From: Martyn White <Martyn.White@arun.gov.uk>
Sent: 15 July 2022 16:56
To: Planning.Responses <Planning.Responses@arun.gov.uk>
Subject: AB/82/22/L

AB/82/22/L

45 Tarrant Street Arundel BN18 9DJ

Listed building consent to create new en-suite bathroom in 3rd floor bedroom, storage cupboard on 3rd floor landing and new garden room.

Proposed Third Floor Plan
1:50 @ A3

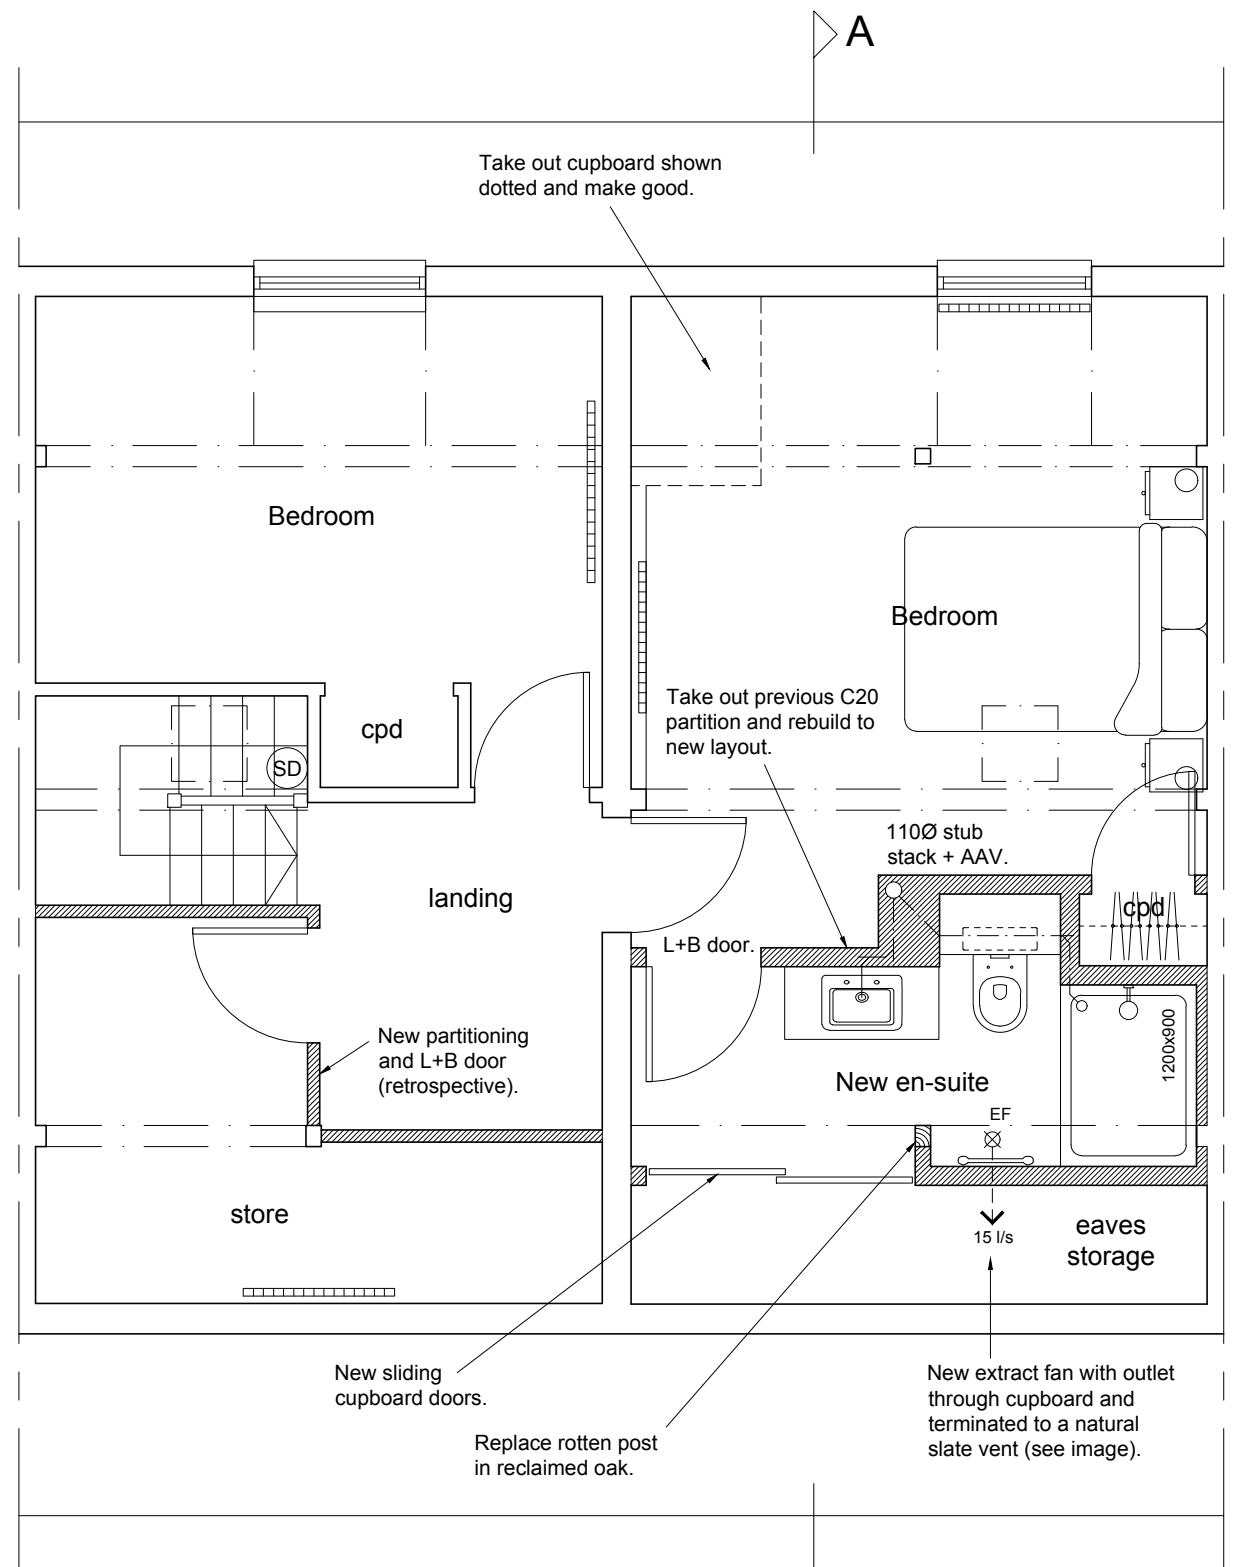
Internally, the proposal will include the removal of an existing wall and the insertion of a new one. I note that the proposed floor plans indicate that this partition is of C20 date, which would mean that it is of little or no significance. Its removal would therefore be acceptable. The creation of an additional bathroom would seem to be acceptable, and it appears that careful thought has been given to the issue of drainage. On balance, this element seems to be acceptable. I would want for any joinery (skirting etc) to match the existing and note that the doors will replicate the new one provided for the store.

I also note that part of the internal works have already been implemented without consent first being sought. This is disappointing, but at least this is now being rectified. It is not clear what the previous floor plan consisted of as the both the existing and proposed floor plans look to be the same for this element of the application. However, that aside, the layout would appear to be acceptable and can be supported. As with all cases, it should be stressed that consent should be received prior to undertaking the works.

Proposed East Elevation
New Garden Room
1:50 @ A3

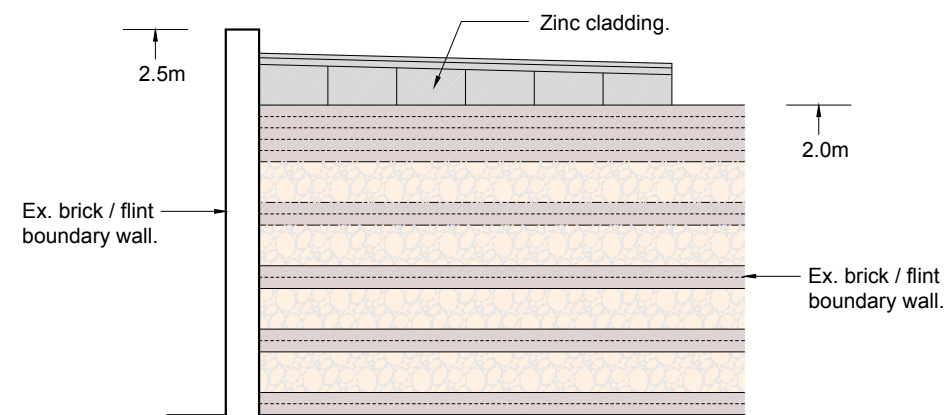
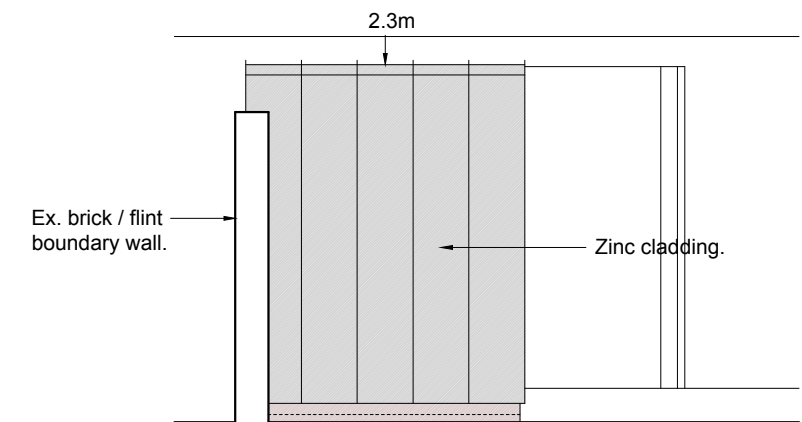
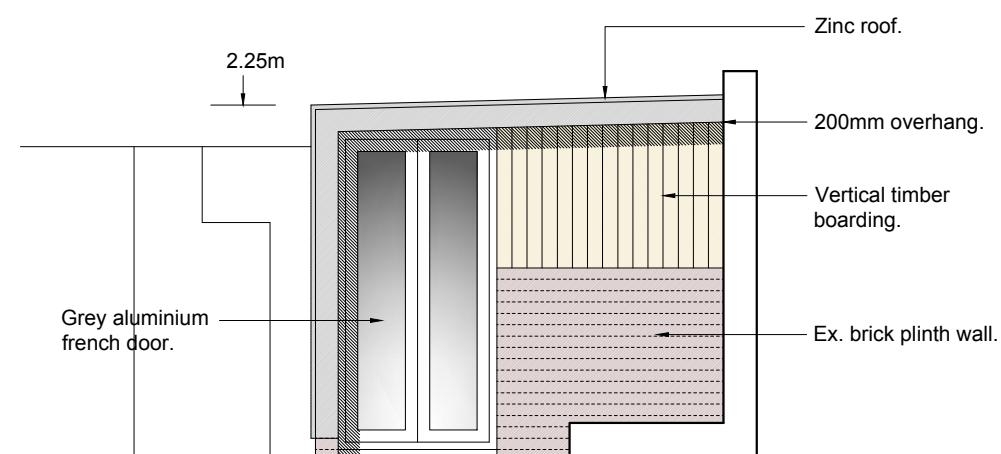
The new garden room is a small structure that takes advantage of some existing brick / flint walling, whilst also incorporating some elements of modern fabric. The design and additional

materials such as the zinc all seem to be acceptable and, based on their location (in the rear garden space), will not cause harm.

The mortar for re-bedding and repointing will should reflect the existing material present. I believe that the previous planning application identified that it would comprise lime with well-graded sharp sand to manufacturers recommendations. The finished colour of the mortar will depend upon the sand used and samples must be prepared to ensure a good colour match to the existing mortar present.
